TRANSPORT FOR LONDON

M25 JUNCTION 28 IMPROVEMENTS – DEADLINE 4 SUBMISSION

17 MARCH 2021

Client	MR L JONES & MRS K JONES			
	FOR APPROVAL			
Project	GROVE FARM ACCESS, JUNCTION 28 M25 NORTHBOUND SLIP LANE			
	SUGGESTED ALTERATIONS TO GROVE FARM HIGHWAY ACCESS			
Status	Drawn	PL	Scale	1:500
Sheet Size	A3	Date	JAN 2021	Rev
Drawing No.	REDW-3396-111			Rev

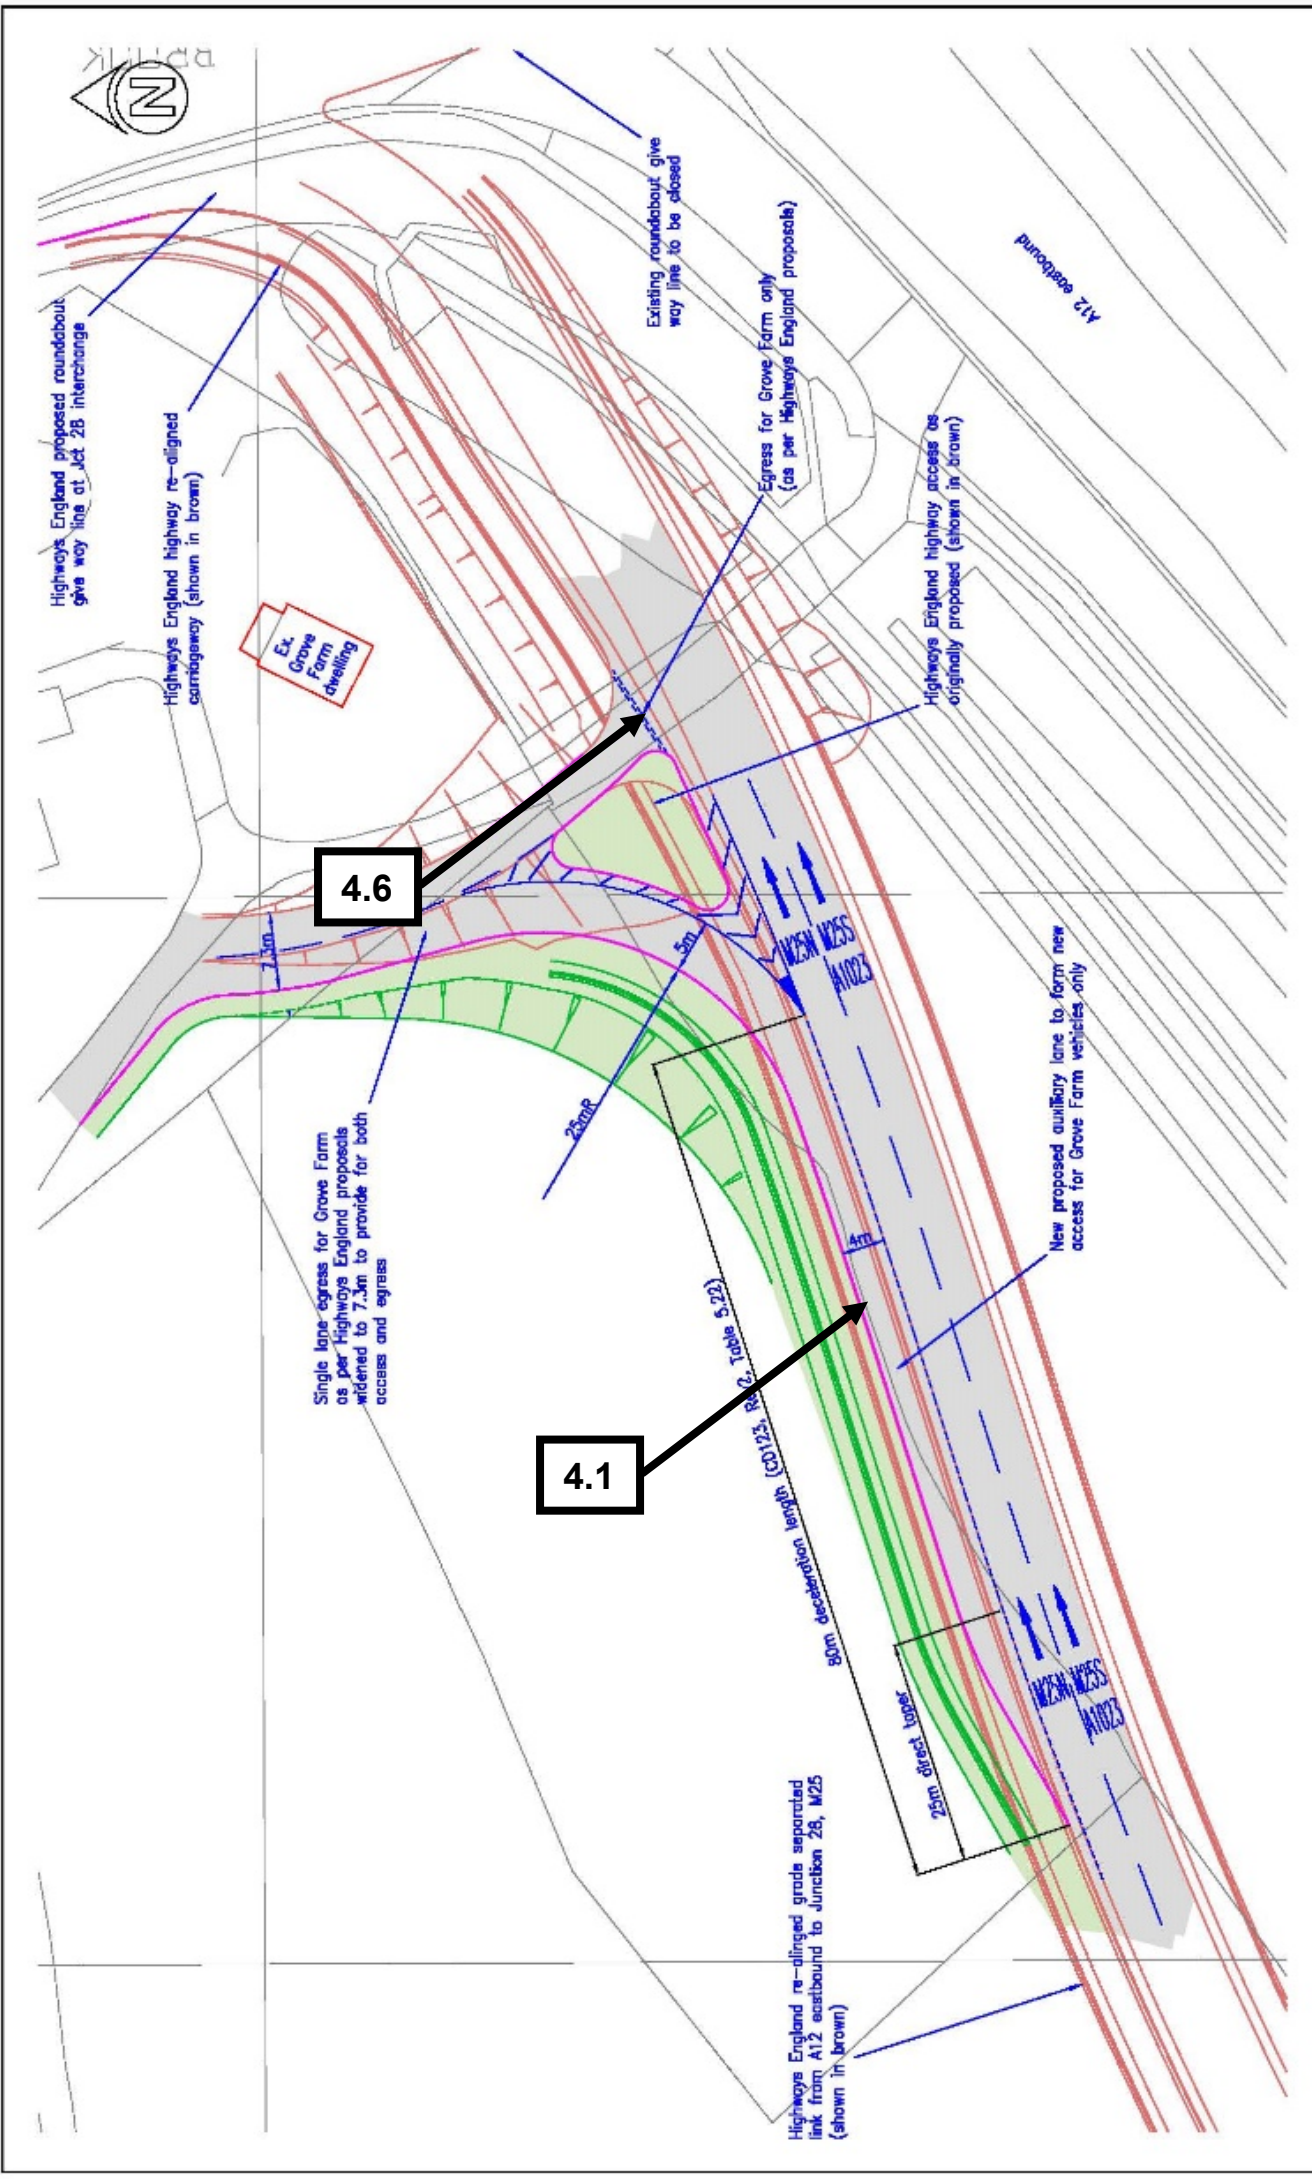
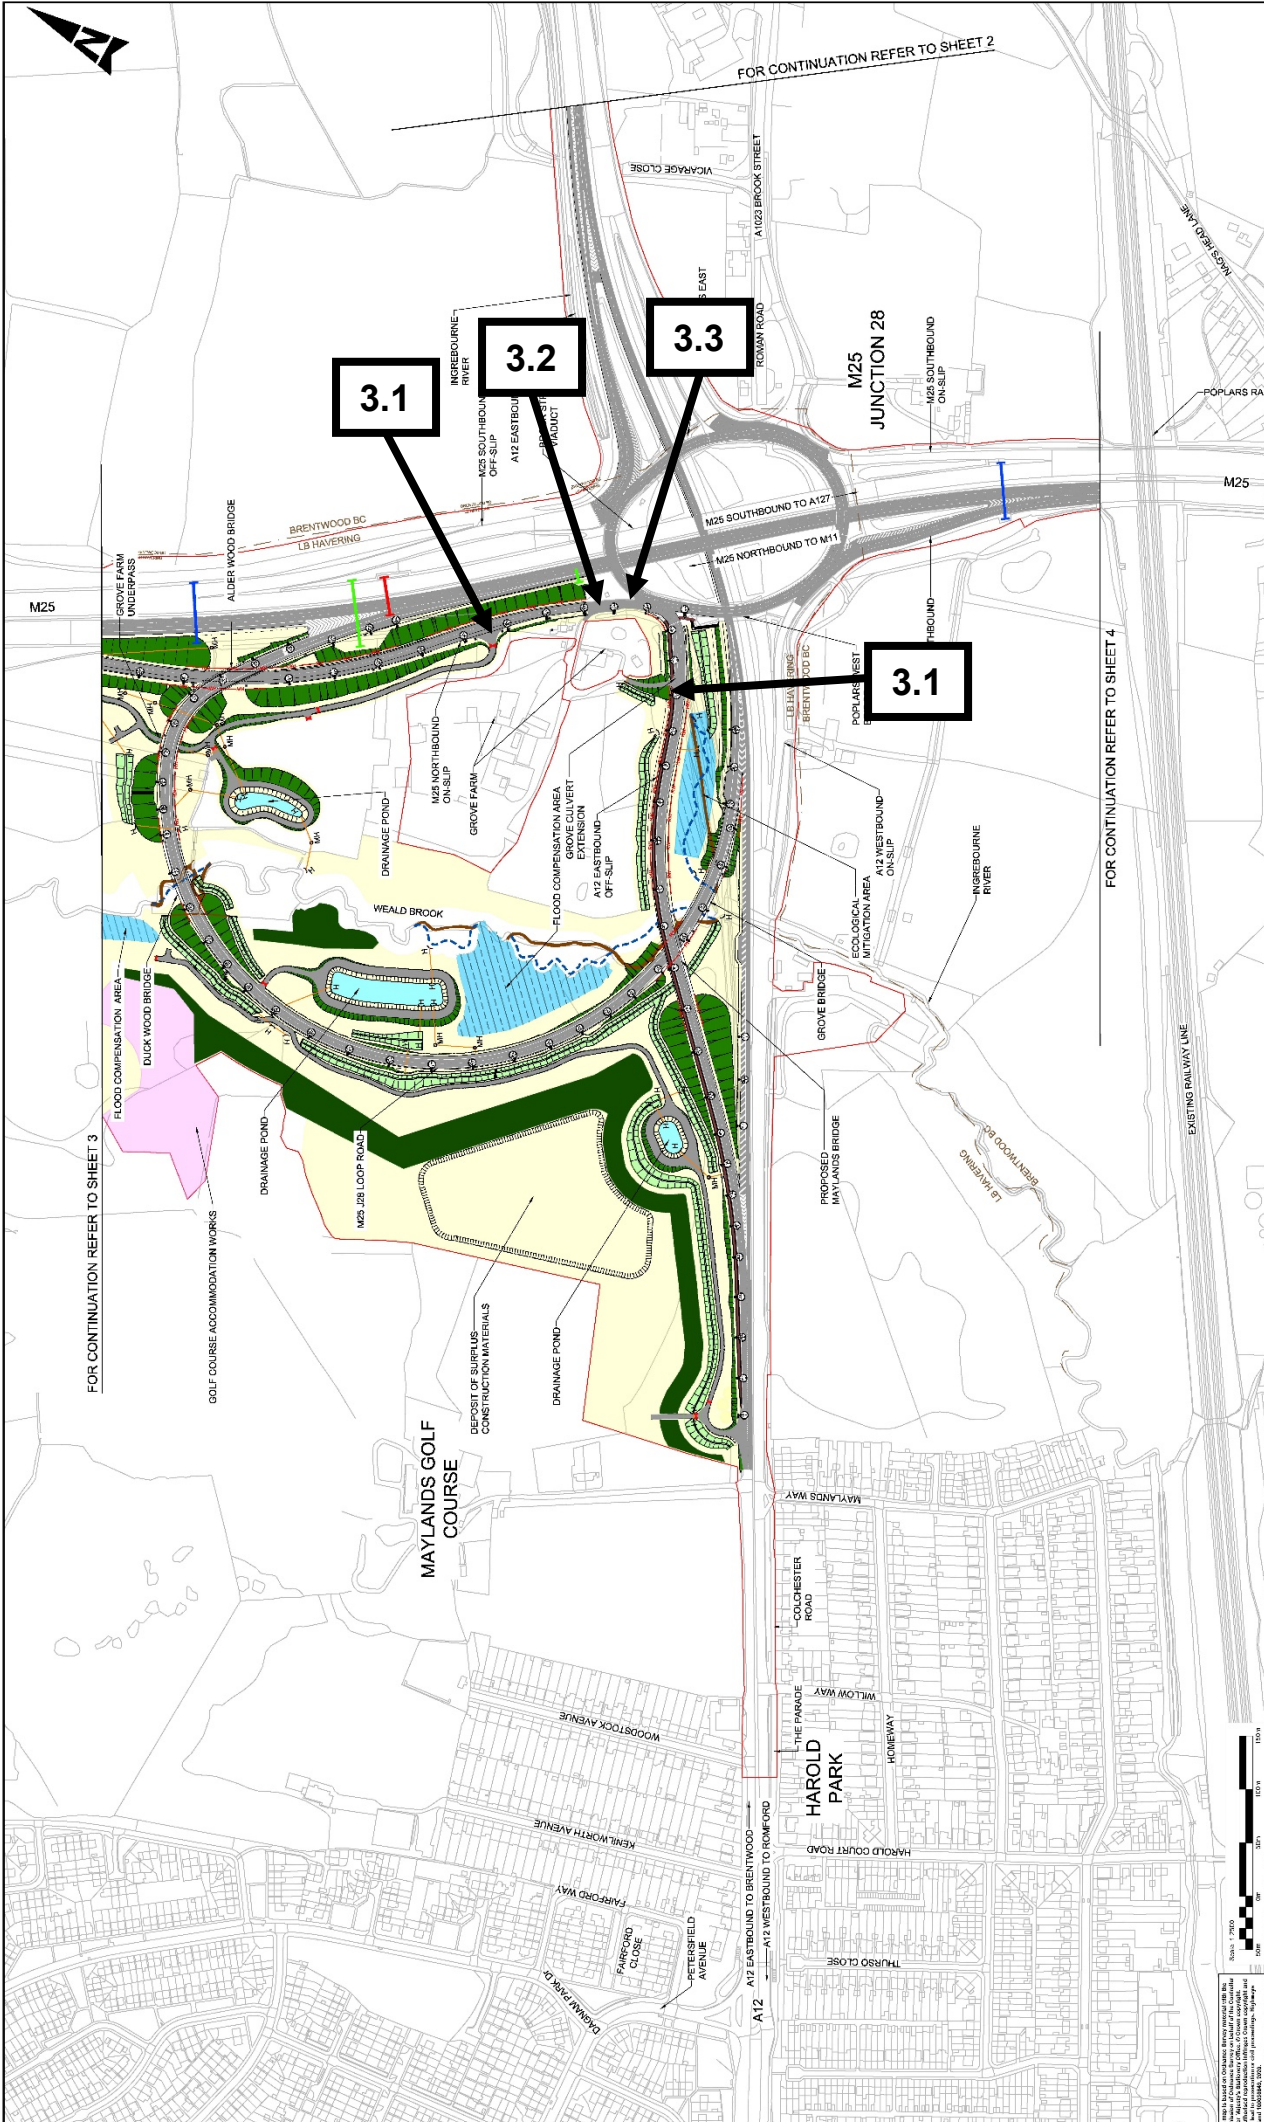
- 3.7.1 TfL set out its views on the proposals for amendments to the access routes to Grove Farm that had been put forward at Deadline 2, noting that it did not wish to comment on the

- 3.7.2 TfL has no issue with the egress from Grove Farm being provided like-for-like, as currently proposed as part of the scheme, if TfL is to take responsibility for the new A12 eastbound off slip road. However, if this egress was converted to also provide an access into Grove Farm, with a left turn only lane provided, TfL considers that there would be an increase in safety related risks on the slip road.

- 3.7.3 The provision of a new access on a slip road may form a departure from the Design Manual for Roads and Bridges (DMRB) standard on the geometric design of grade separated junctions. The DMRB specifies that direct accesses and priority junctions shall not be provided.

- 3.7.4 TfL also notes the concerns raised by the Applicant about the potential for drivers to mistake access to Grove Farm with access to the northbound M25.

- 3.7.5 Considering these points, TfL is broadly in agreement with the Applicant's concerns about increased road safety risks associated with the Grove Farm access proposal, however it is for the Applicant to consider the overall road safety impacts of the proposal as a whole given this also affects road safety on the M25 northbound on slip.
